Subject: RE: Application for 2 x 15m turbines in AONB, near Longridge 3/2011/0734/P

In my previous comments I highlighted a number of weaknesses and omissions with the applicant's landscape and visual impact assessment (LVIA). I drew attention to these issues as I see the LVIA as a critical part of the applicant's documentation which should provide the local planning authority with the information needed to make informed judgements on the acceptability of impacts. Having reviewed the information posted on Ribble Valley Borough Council's website in connection with the above application I find that some of the issues I previously raised have still not been addressed, the principal being:

2 x Proposed 15m Wind Turbine.
View Point 5

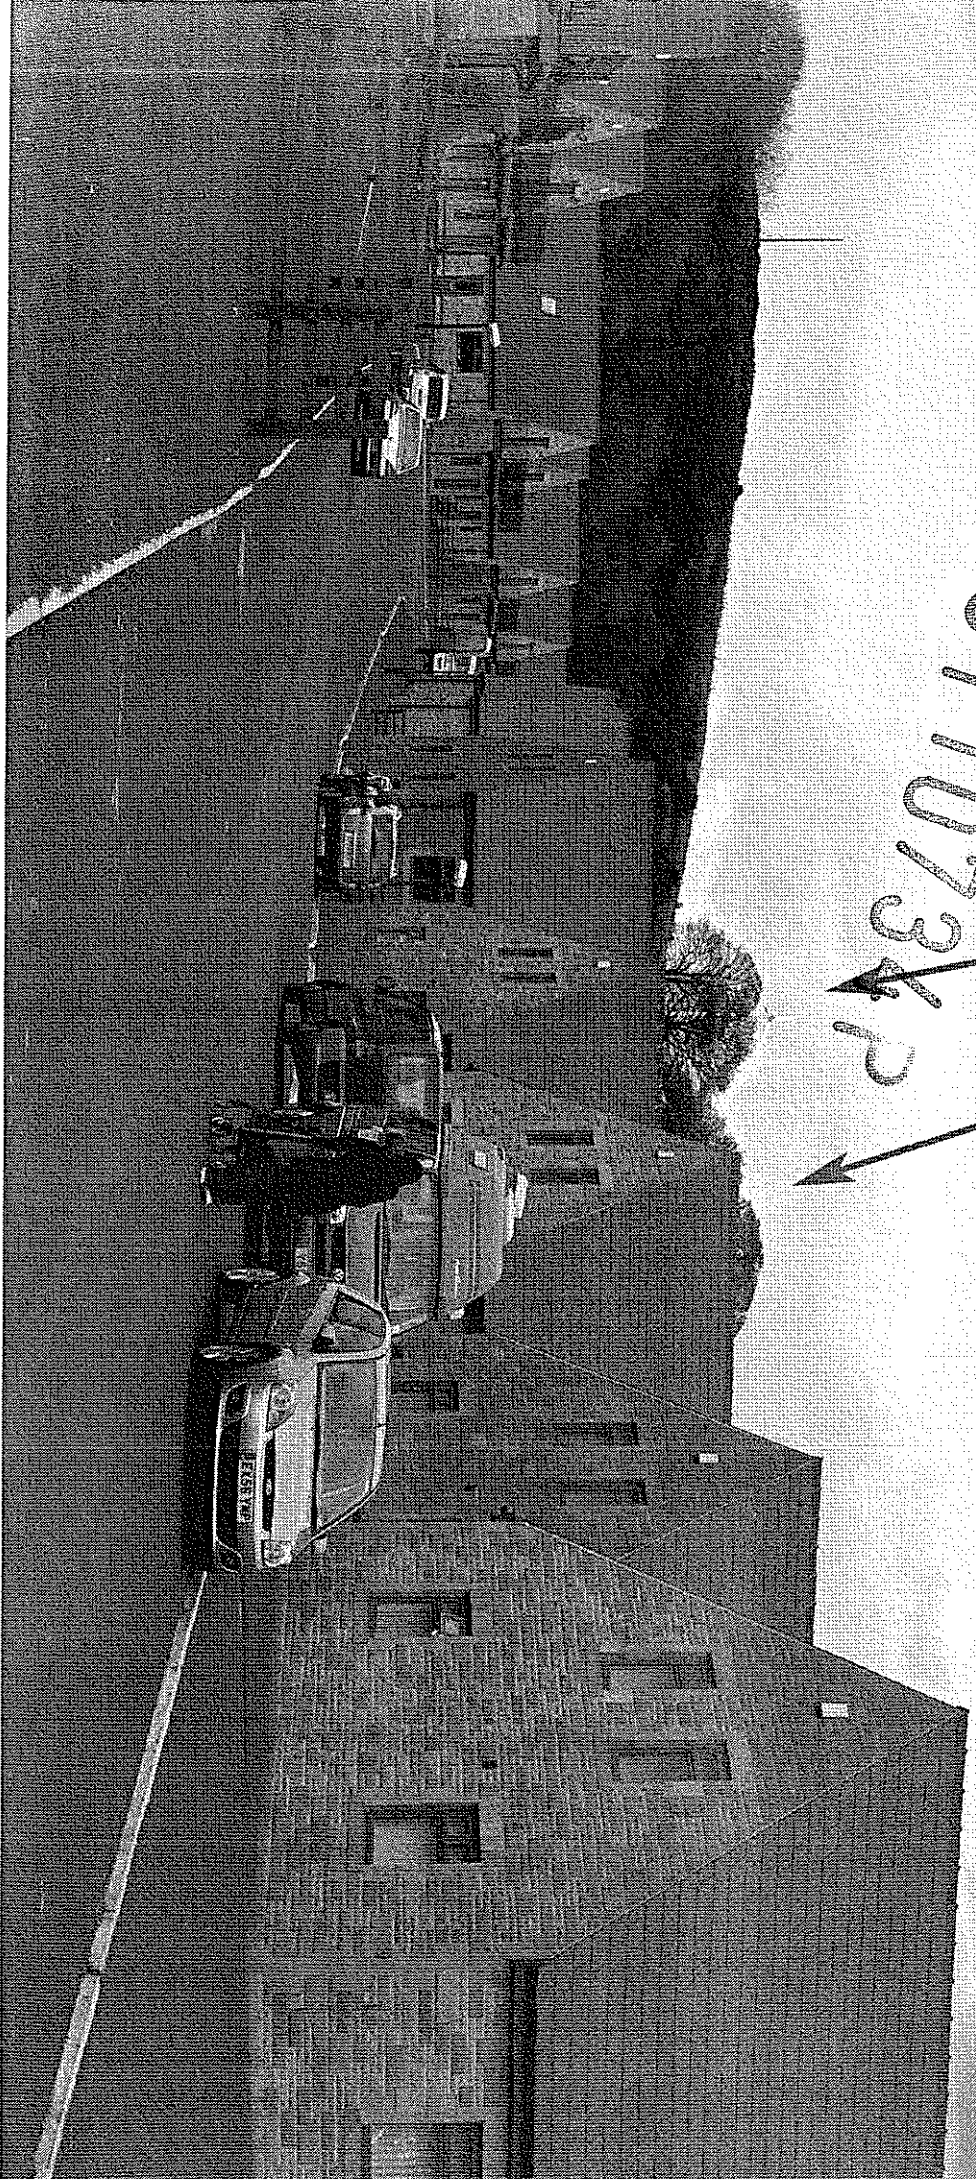
The information requested in my previous comments e.g. image production methodology, viewing distance and image height has still not been provided. Unhelpfully the viewpoint locations are not supported with six figure grid references which makes it difficult to determine exactly where they are and what the image should show. This might explain the following:

- Viewpoint 5 – image does not appear to match what would be seen.
- Viewpoint 10 – the road in the image bends to the right yet it should be straight for half a kilometre before bending to the left. The rear view mirror of a car is visible in the image.
- Viewpoint 11 – approximately one third of the image is occupied by a car.

Until these issues have been addressed, I recommend that little or no reliance be placed on the photomontages to represent the likely appearance of the wind turbines in the landscape.
